CITY OF ALBUQUERQUE

May 10, 2019

Re: A & S Autocare
4900 2nd St. NW Albuquerque NM 87120
Traffic Circulation Layout
Engineer's/Architect's Stamp **04-19-2019** (F15D054)

SITE PLAN

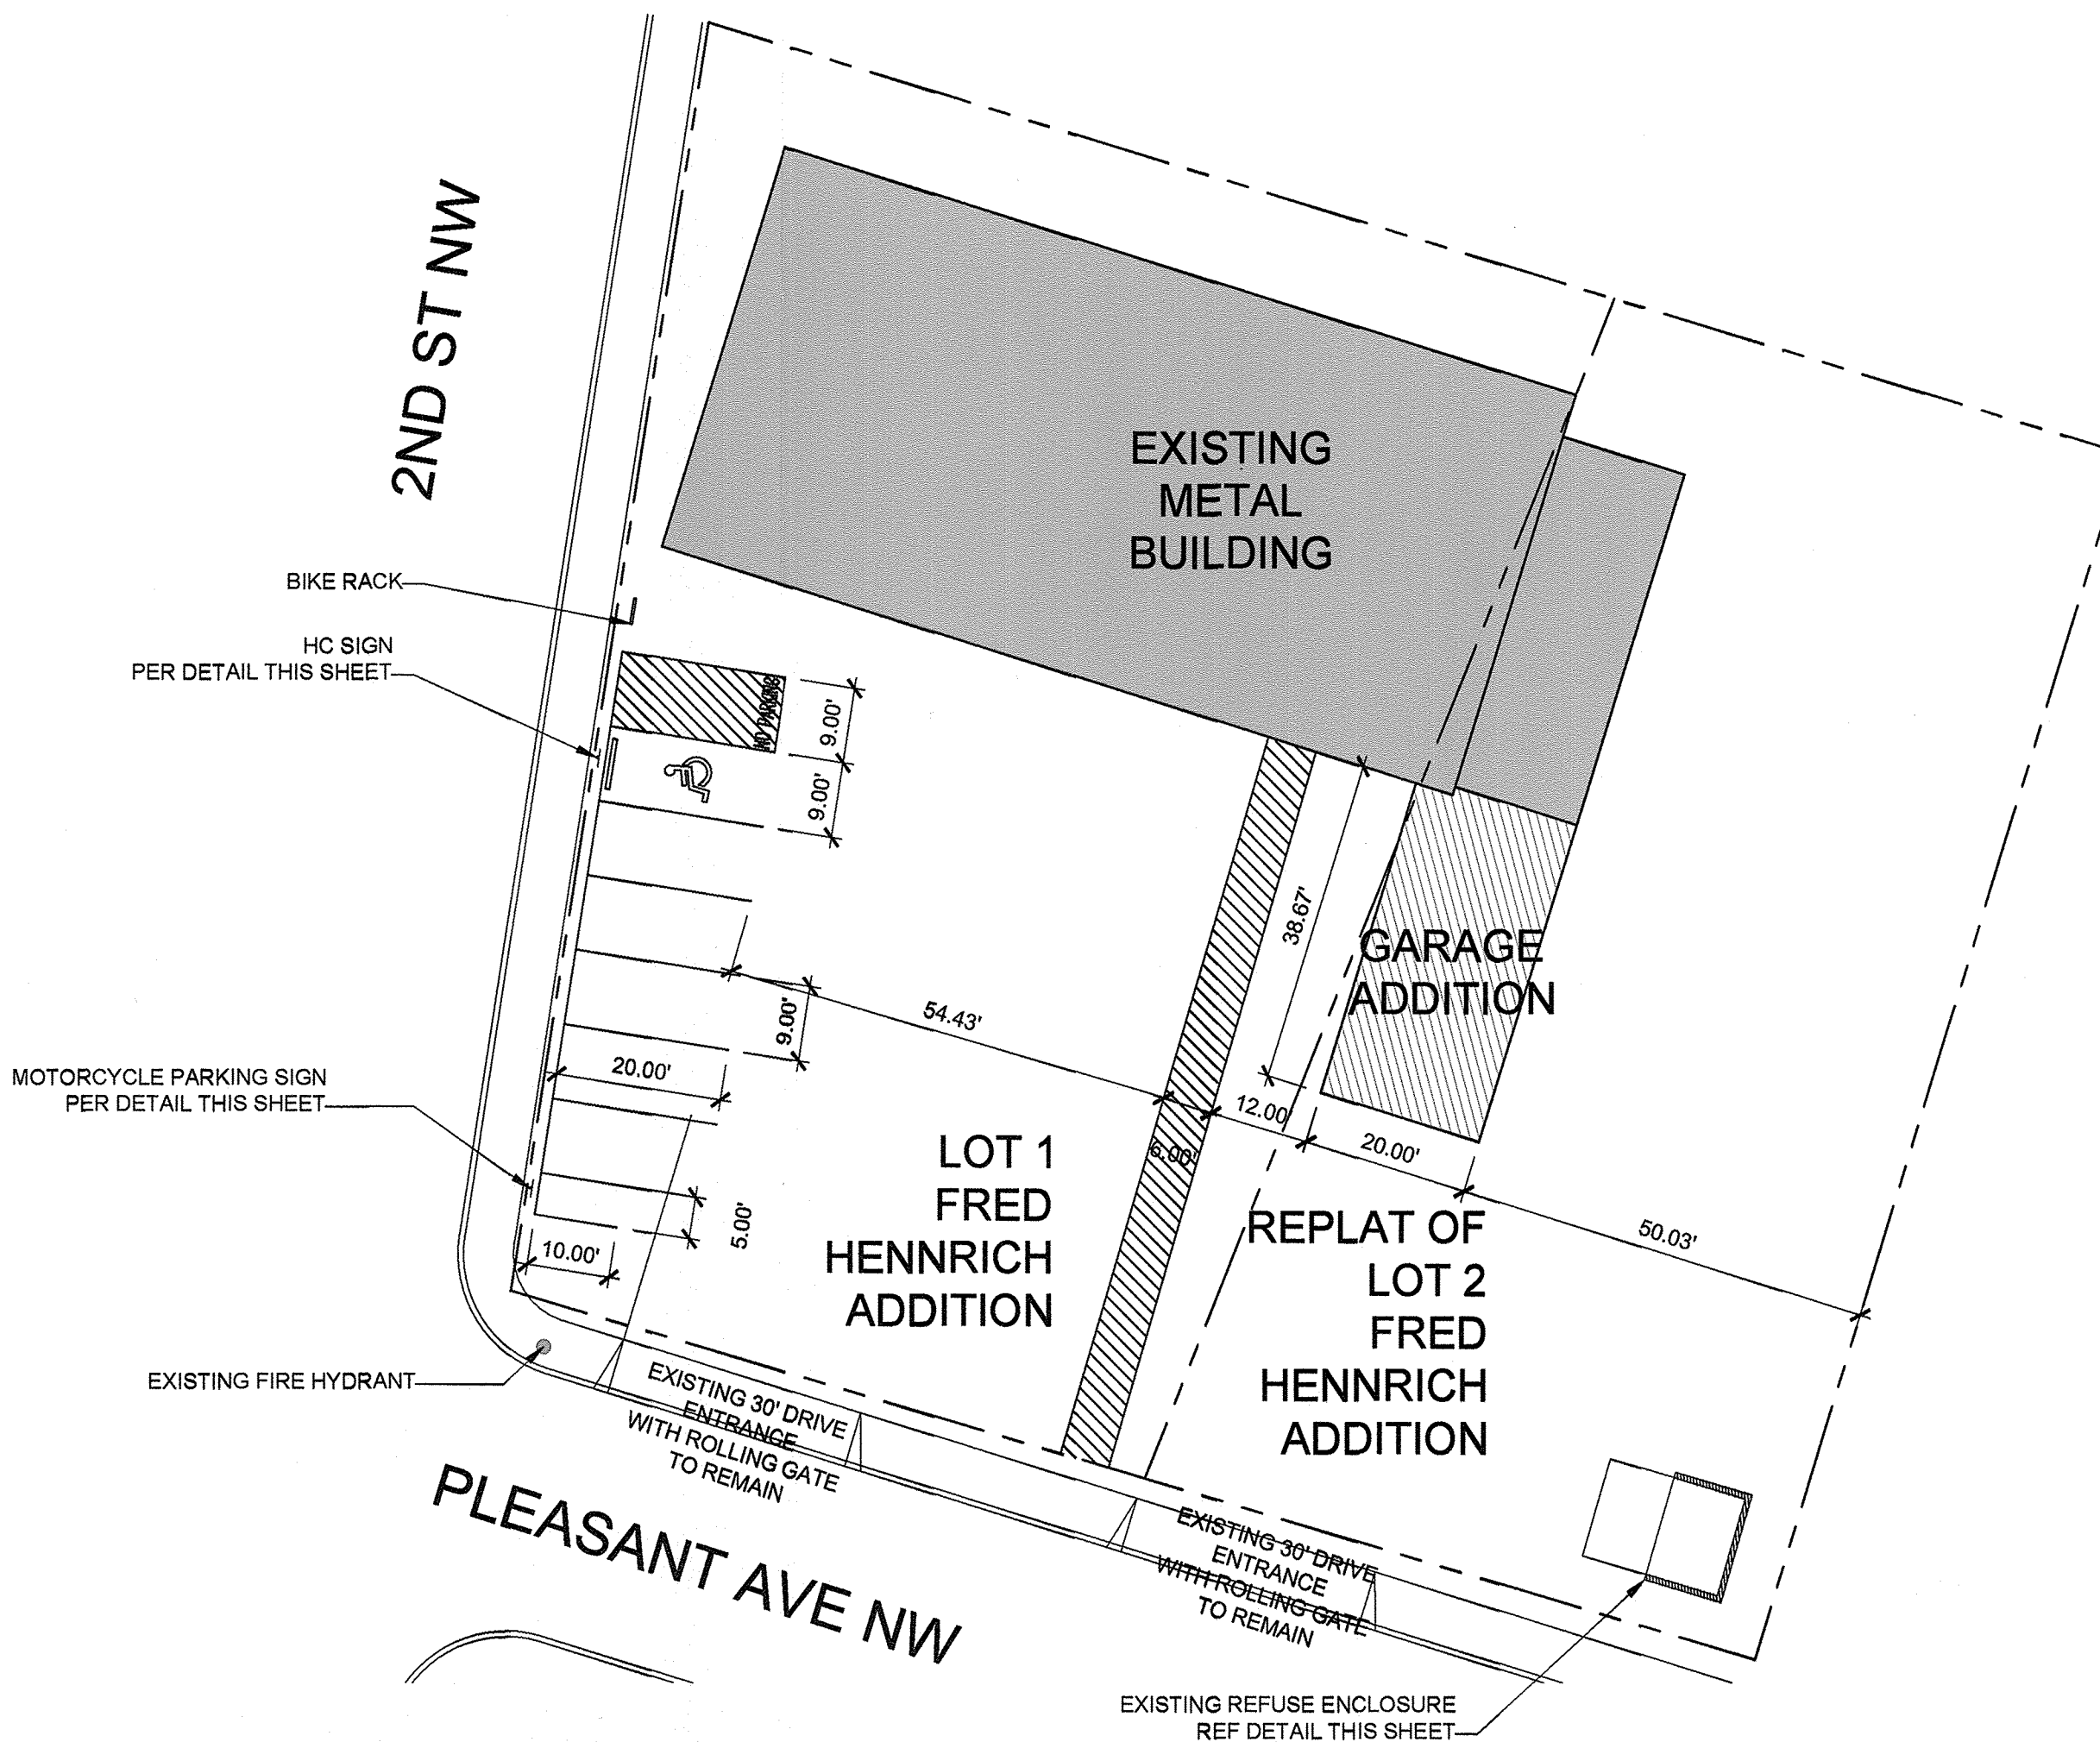
1. Please show a vicinity map **showing the location** of the development in relation to streets and well known landmarks. The one that is shown points to the wrong location.
2. Lot line can not go through the building. A replat is required for this project.
3. Please remove the red fire lane striping from the TCL.
